TfNSW reference: REN25/00060/002  
DPHI reference: SSD-55968733

**SSD-55968733 – Burroway Solar Farm, Advice on RTS, Narromine Shire Council**

Transport for NSW (TfNSW) is responding to the Burroway Solar Farm response to submissions (RtS) referred via the Major Projects Portal.

Figure 4: Turning Movement Count Peak Hour Survey Results

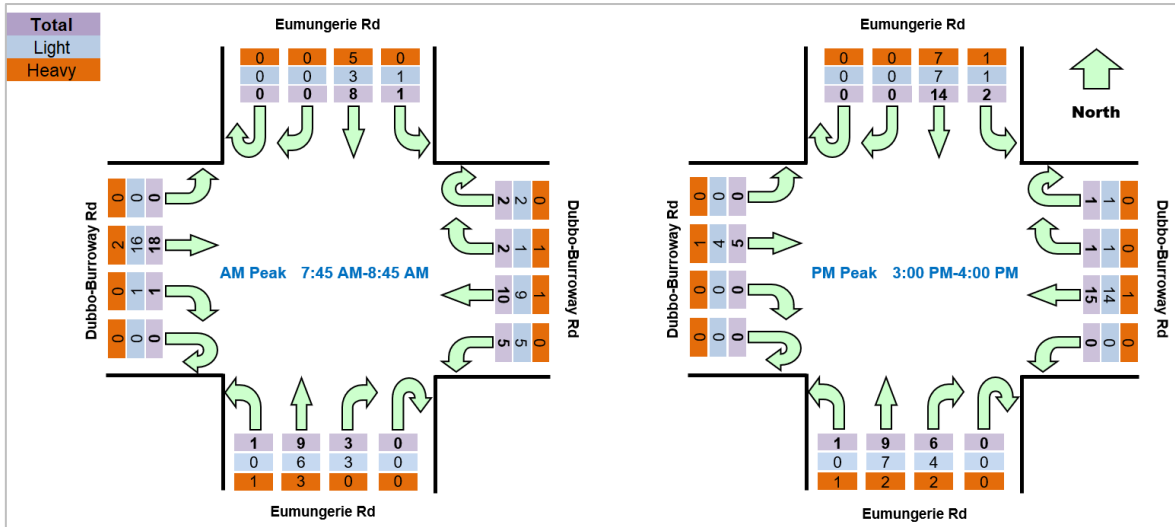
<p>d)</p>	<p>Traffic count survey was collected on a single day in May 2023, which isn't reflective of the worst-case scenario for the network AM/PM peak hour which occurs during the harvest period.</p> <p>Traffic data is to be obtained or collected for the harvest period fluctuation for the Eumungerie Road/Newell Highway intersection and compared to the existing traffic assessment. Any recommendations to minimise the projects traffic impact during this period will need to be included within the revised TIA.</p> <p>Note: Traffic count data could be obtained from GrainCorp or Council for the harvest period for this section of the network.</p>	<p>CLOSED - As per point d of the previous letter, the traffic count survey was conducted on a single day in May 2023. No new updated traffic survey data has been included in the appendix however data has been extrapolated with an 8.7% increase in July for harvest season.</p>

Figure 19: OSOM Vehicle

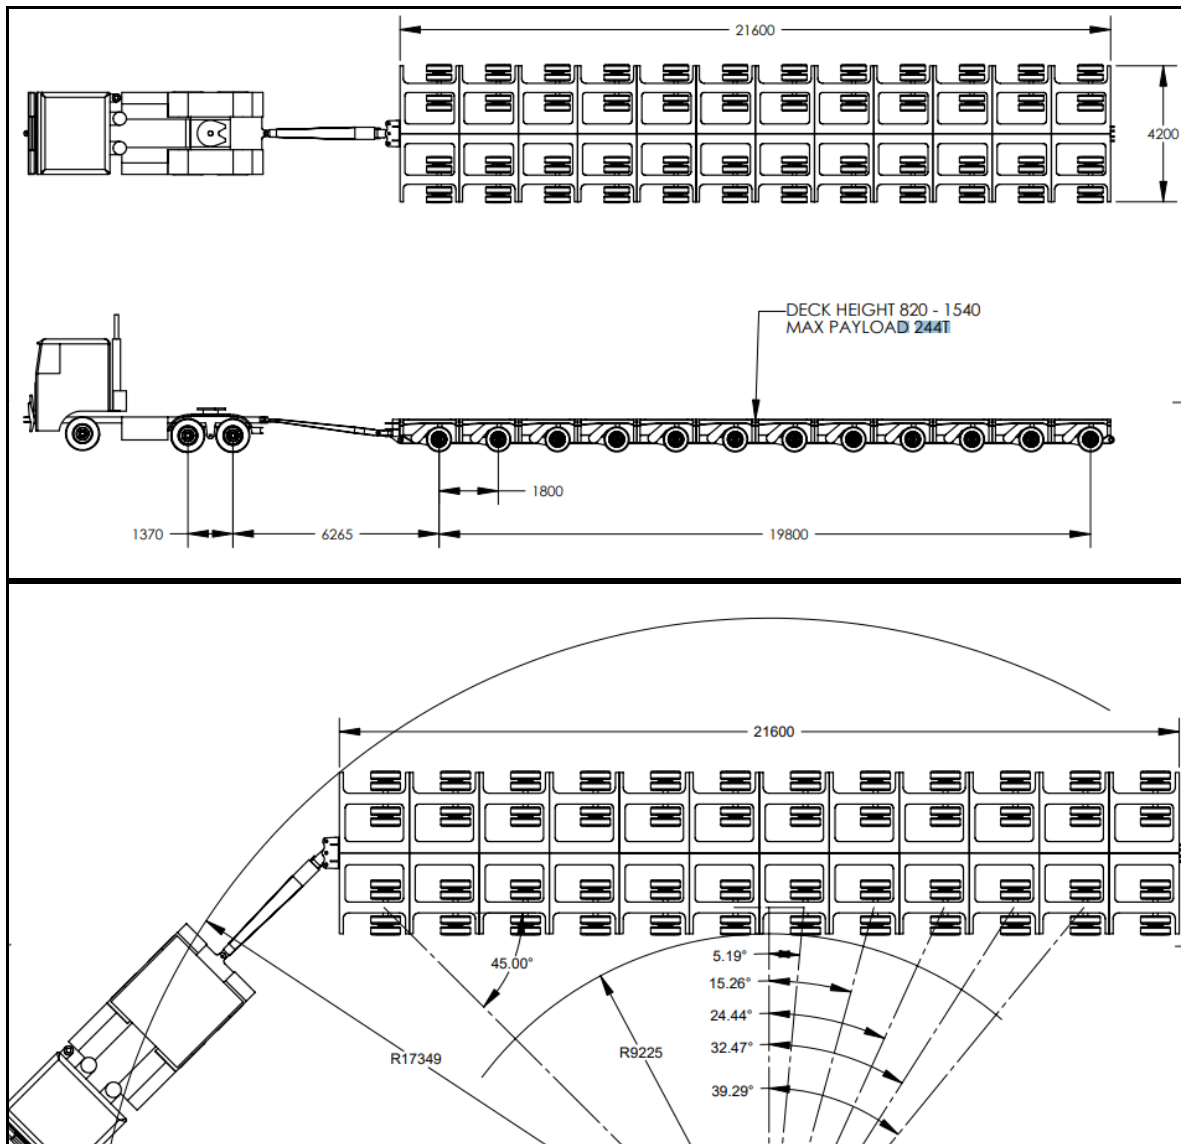
No.	TfNSW comments from EIS requiring RFI	TfNSW response in relation to RTS and request for further information for revised TIA
1	<p>Concept Level Route Analysis required for High Risk OSOM</p> <p>The TIA has not included a Concept Level Route Analysis (high risk OSOM (as defined on TfNSW website)). This analysis must include:</p> <p>a) The port or point of origin and must be for the entire route to the site access or intersections required to facilitate the high risk OSOM movements required for the project.</p>	<p>OPEN - Route Analysis provided in Appendix H of the TIA.</p> <p>TfNSW requires clarification on whether the term vehicle envelope within the swept path analysis represents the wheel path tracks of the high-risk OSOM load.</p> <p>The proponent is to confirm specific dimensions, including weight (currently only a range provided) and if the OSOM-laden loads (vehicle configuration + load) is defined as a high-risk OSOM.</p>

b)	<p>The TIA is required to include details of all high risk OSOM loads and vehicle configurations for the project.</p>	<p>OPEN - See comment above.</p>
